Comment Correction Required / Response Report

Application No. PDZL-24-0005

P:\2024\24-1010_BLR_Village_C\Drawings\241010_BLR_Village_C_Land_Use_Plan.dwg 6/13/2025 10:27 AM

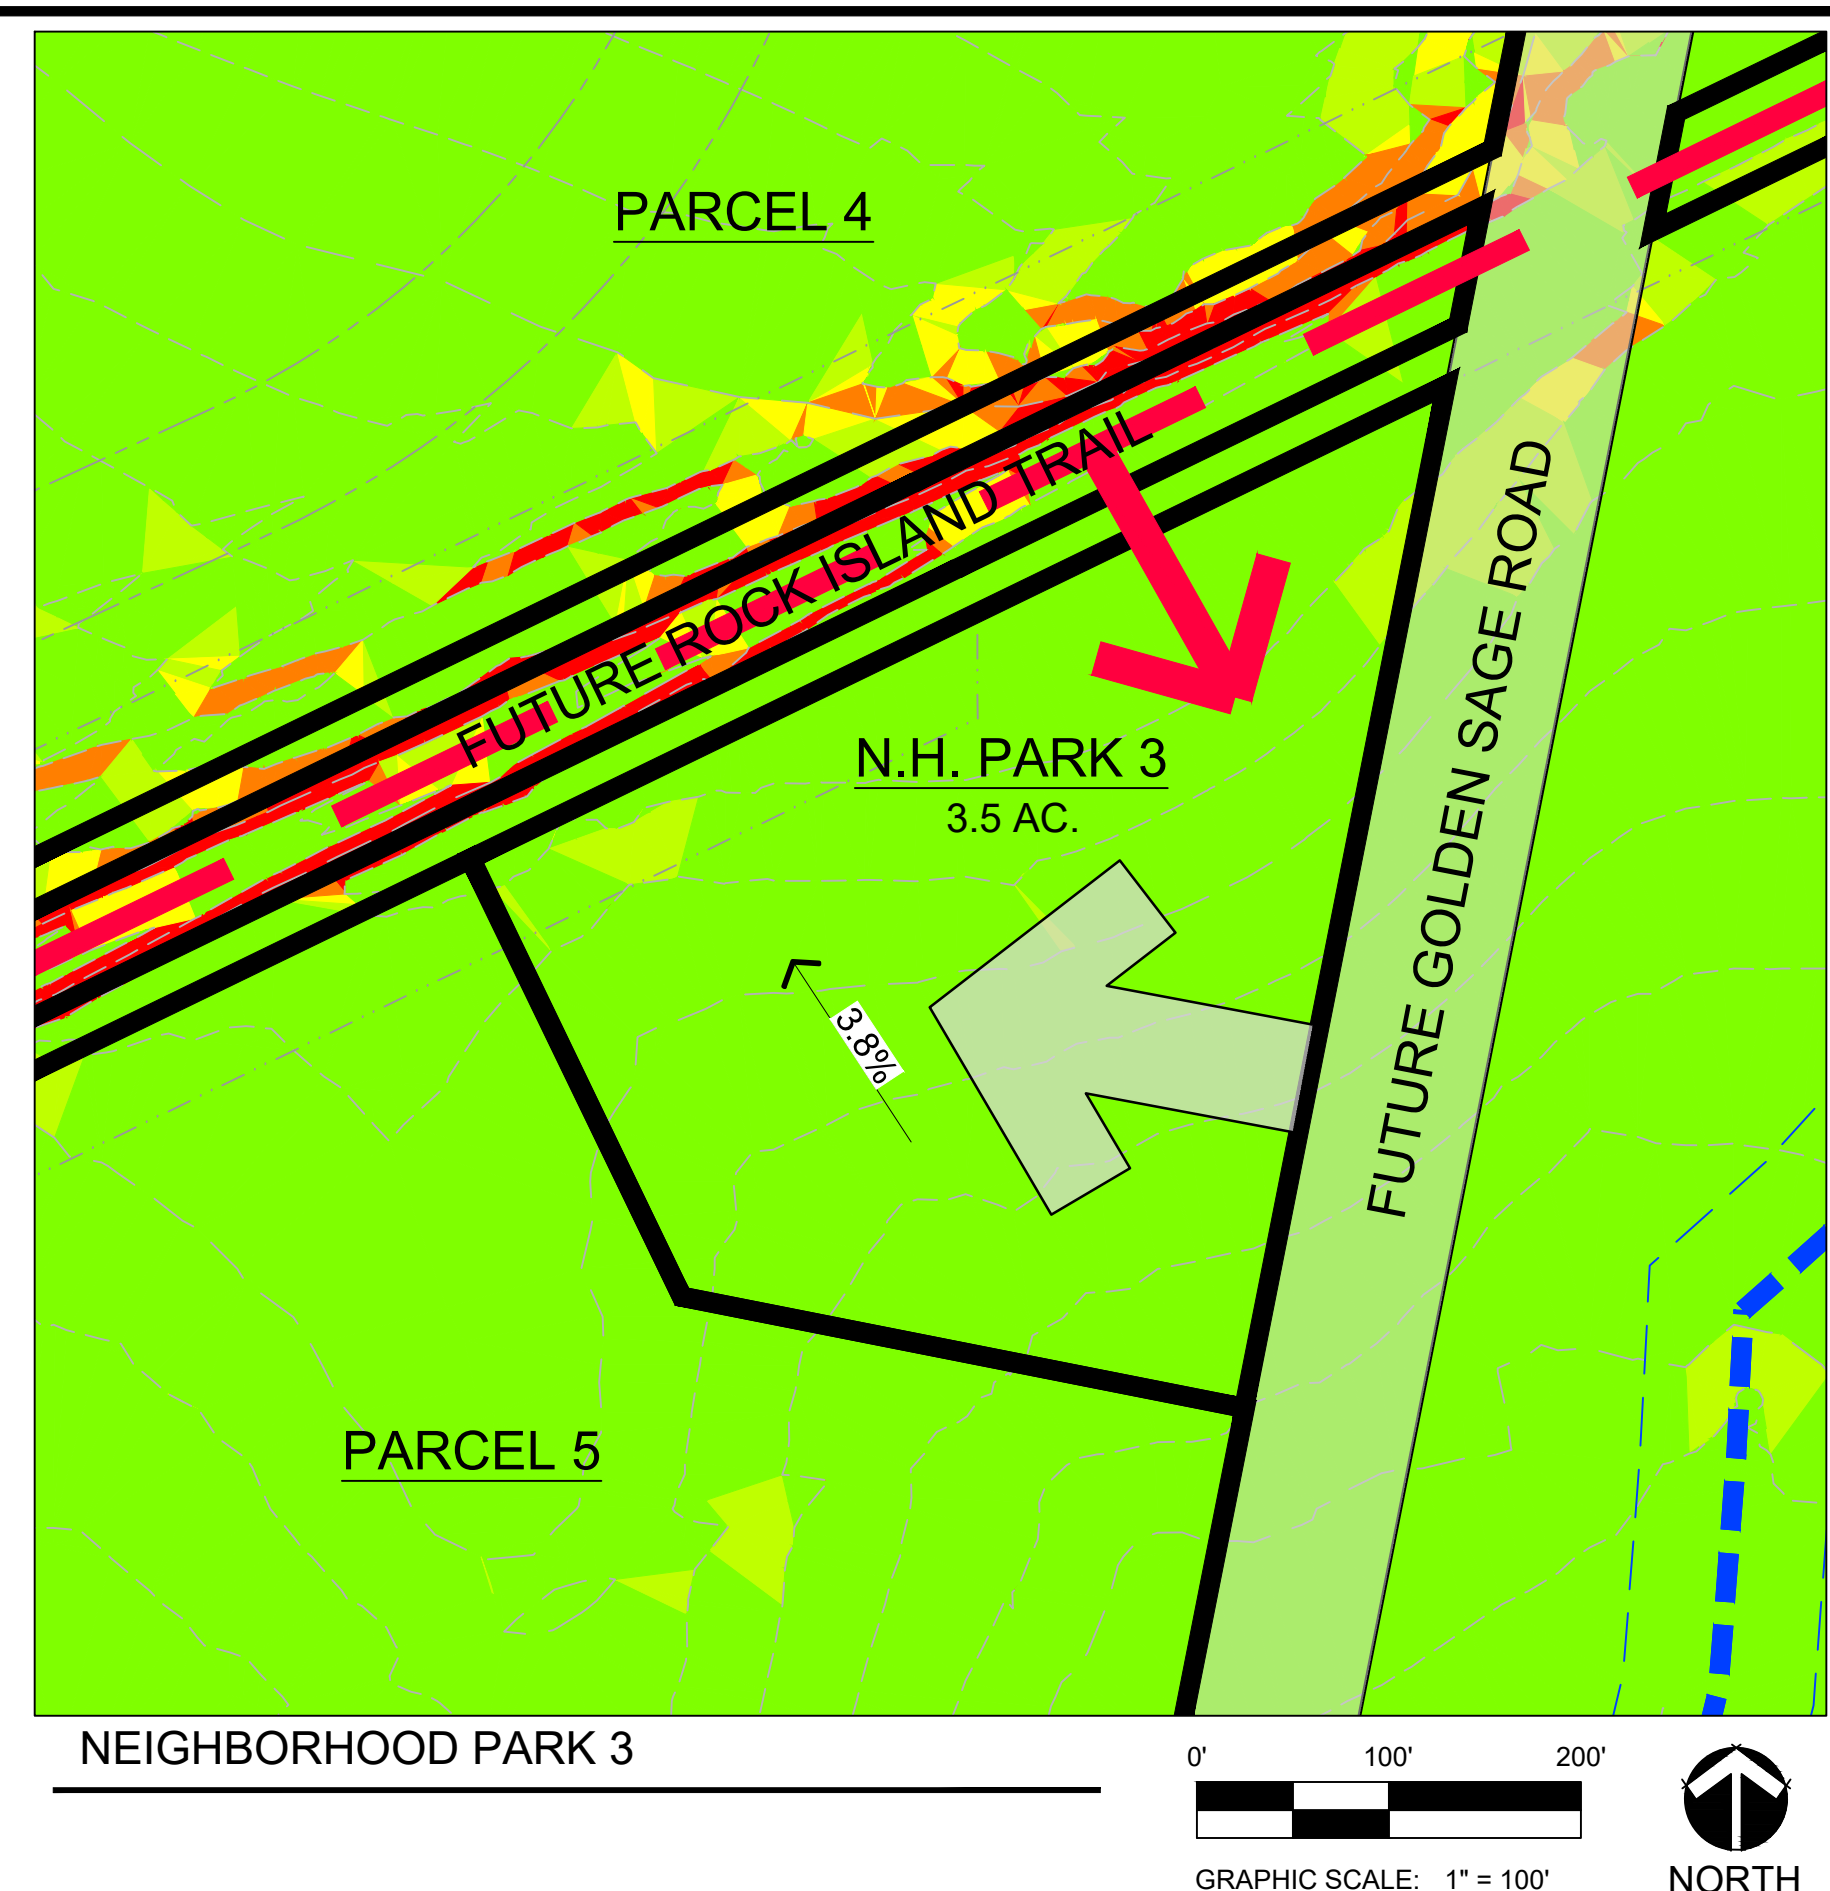
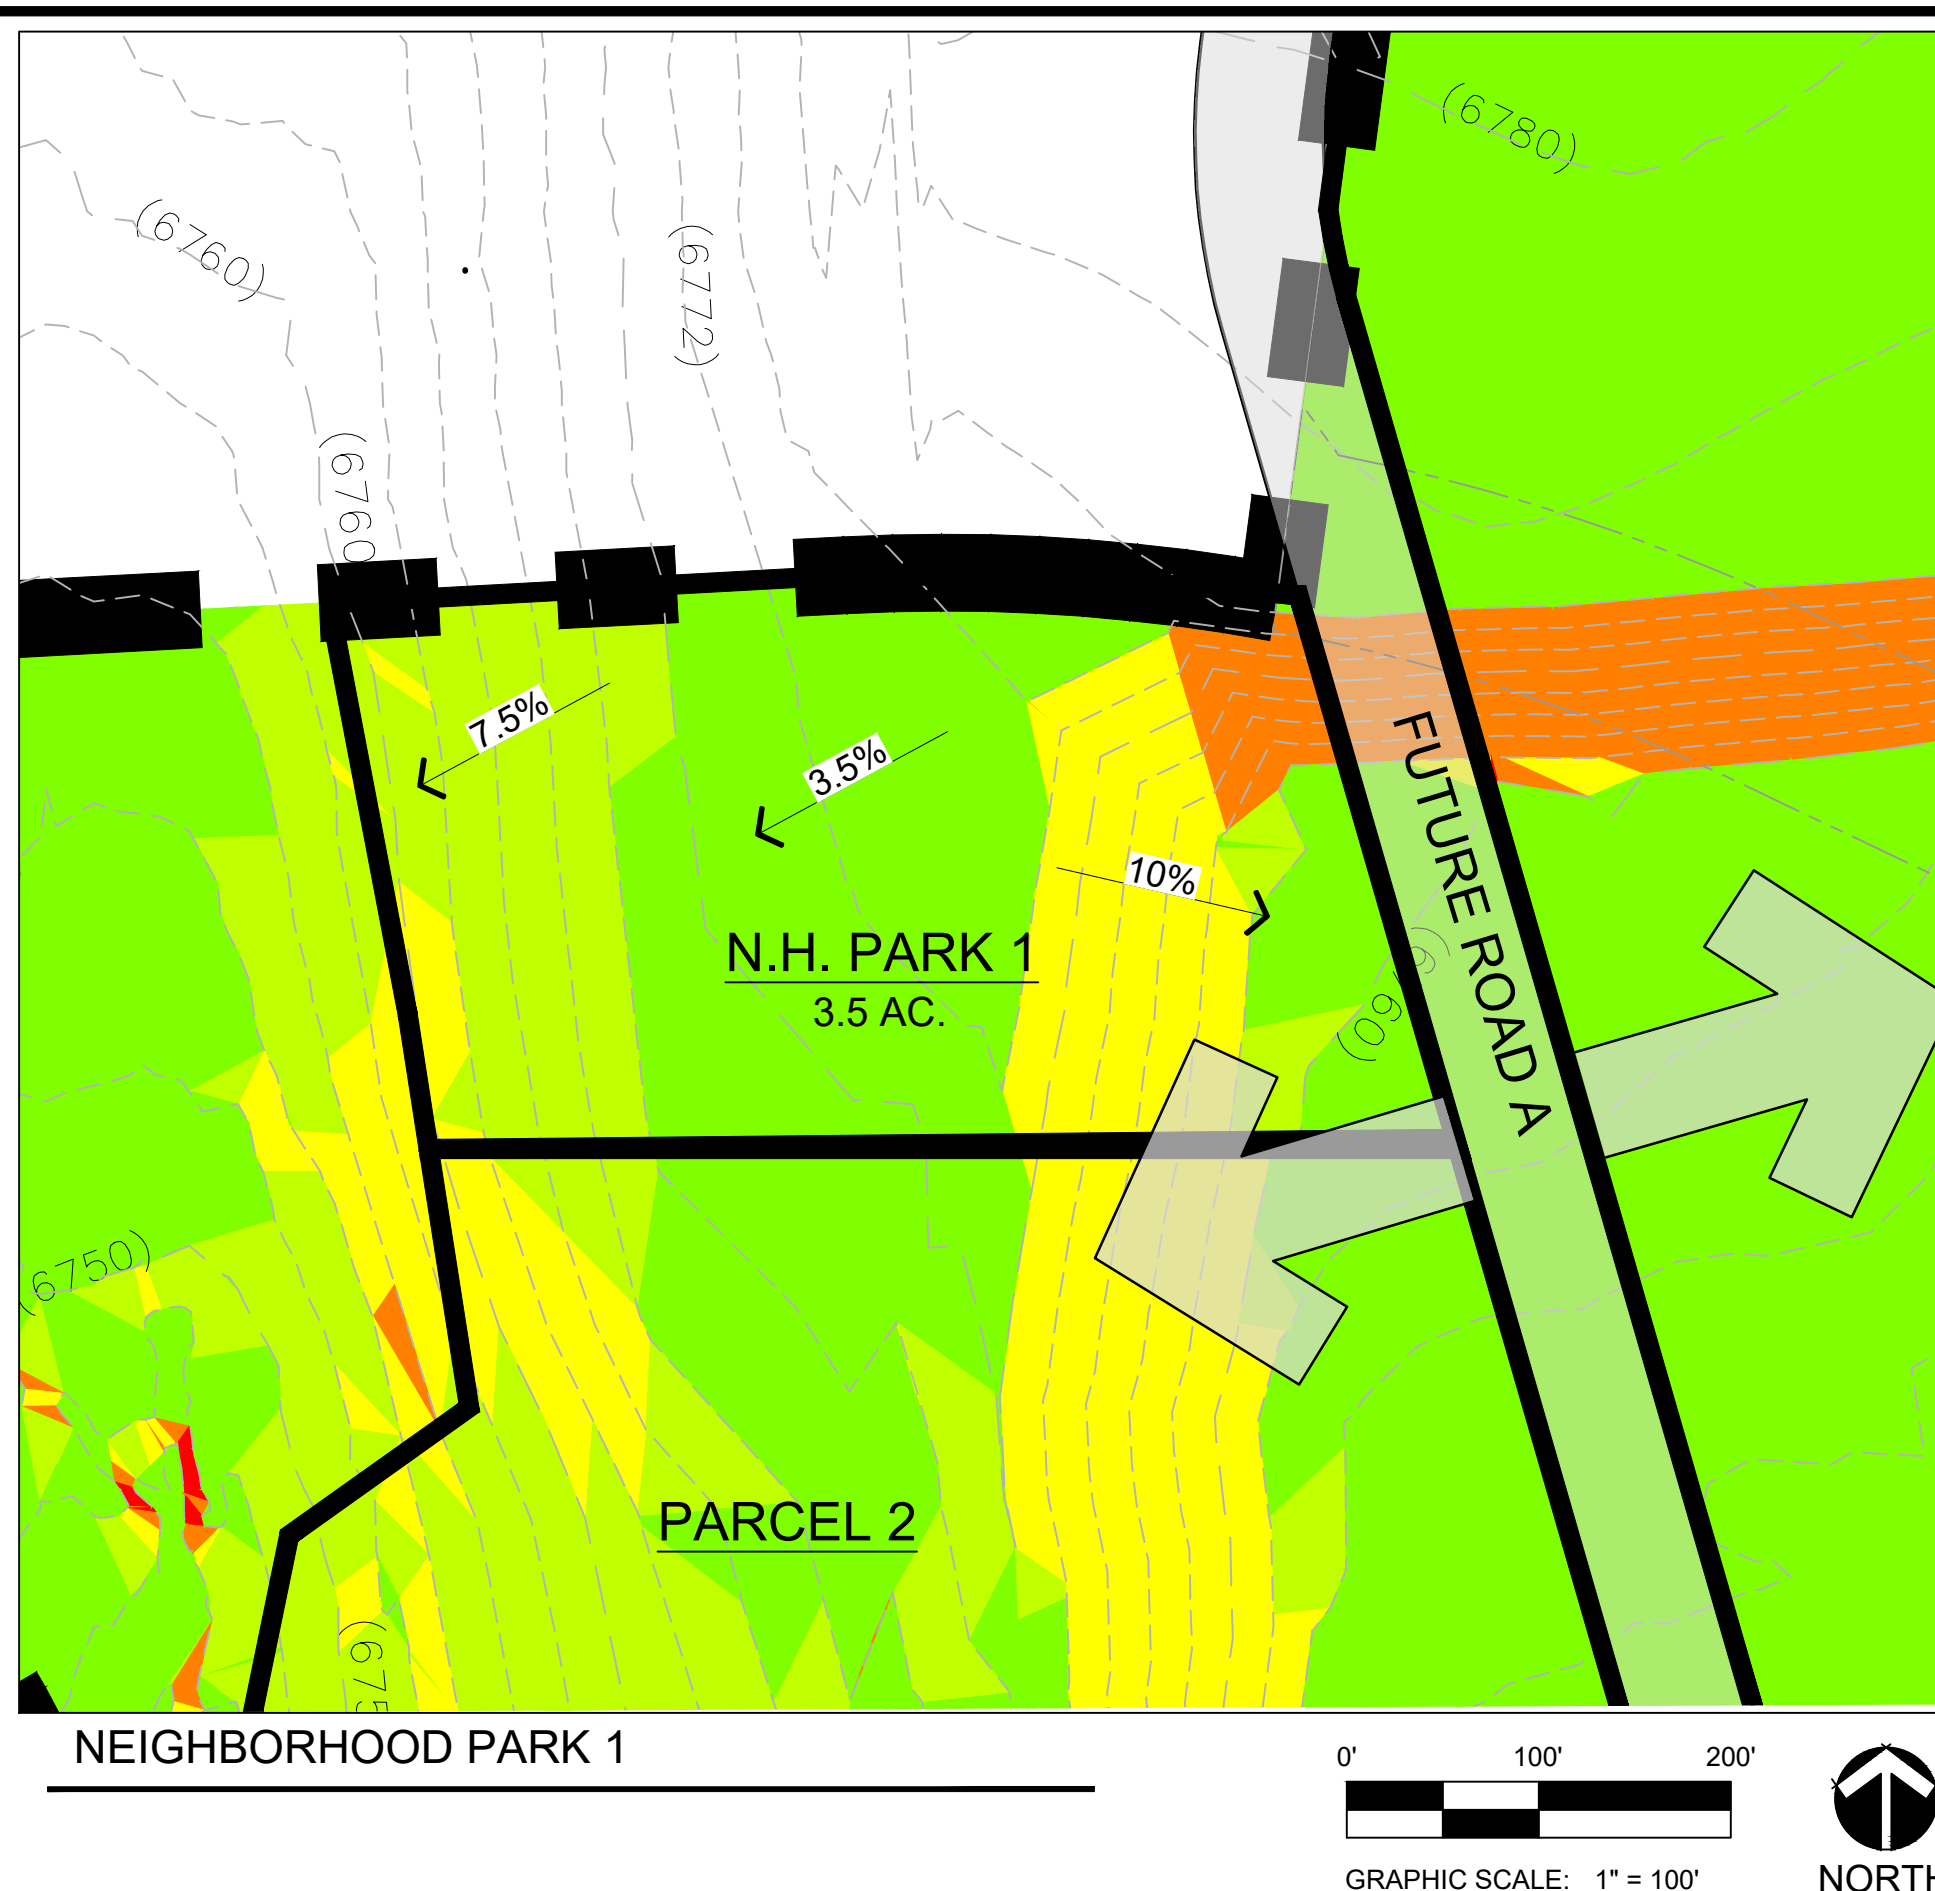
2	2	Note	Zaker Alazzeh : City Eng - Traffic Engineering	Open	1- The developer shall dedicate appropriate ROW along northern property line of Parcel 6 side at Dublin Blvd. This dedication must be consistent with the western property line ROW. 2- Please update the traffic study. Details are shown in the traffic impact study review comments.	RESPONSE: Please see included T.I.S comment response letters from S.M. Rocha dated March 26, 2025.
15	1	Free Text	Jonathan Scherer : City Engineering - SWENT	Open	Show and label all major drainageways on the vicinity map.	RESPONSE: Added.
16	1	Free Text	Jonathan Scherer : City Engineering - SWENT	Open	In the Floodplain Statement, include which flood zone the Site lies within (e.g. Zone X).	RESPONSE Added.
17	1	Free Text	Jonathan Scherer : City Engineering - SWENT	Open	The Site also appears to be located within Panel 08041C0561G. Please include within the Floodplain Statement.	RESPONSE Added.

45	2	Note	Caroline Miller : Planning	Open	Have there been considerations of moving the N.H. Park 3 east of the utility easements to serve the residential communities of Parcels 6, 7, and 8? It is still within a half mile of walking distance along the Rock Island trail which is park standard, but by vehicle park access is further. Phasing may also play a role in this.	RESPONSE We agree that there should be a park east of the utility easement. We have added a 4 th park to serve this area. We are projecting (4) 3.5 acre Neighborhood parks which exceeds the requirement projection of 12.151 acres.
46	2	Note	Caroline Miller : Planning	Open	As shown, there is a need for pedestrian bridges to allow connection to the Community Park site. Will the developer provide those?	RESPONSE Yes the developer will provide access over the drainageways to the community park. The type of crossing has not been determined.

54	2	Note	Caroline Miller : Planning	Open	Please add a note that the Rock Island Trail Corridor easements will be provided to the City at time of adjacent development.	RESPONSE: Rock island trail has an existing easement that varies in width 100-200'.
68	2	Callout	Tamara Baxter : Planning	Open	Please expand if 'dwelling - two family (duplex)' will also be allowed per UDC.	RESPONSE *Note has been added for clarification.
75	2	Callout	Tamara Baxter : Planning	Open	Refer to Staff comments on proposed PDZ zoning, not meeting eligibility for PDZ district. Conventional zoning is encourage. Thus, density for specific parcels make need to be updated.	RESPONSE: Zoning has been revised to R-flex Medium and MX-M per recommendation of planning staff.
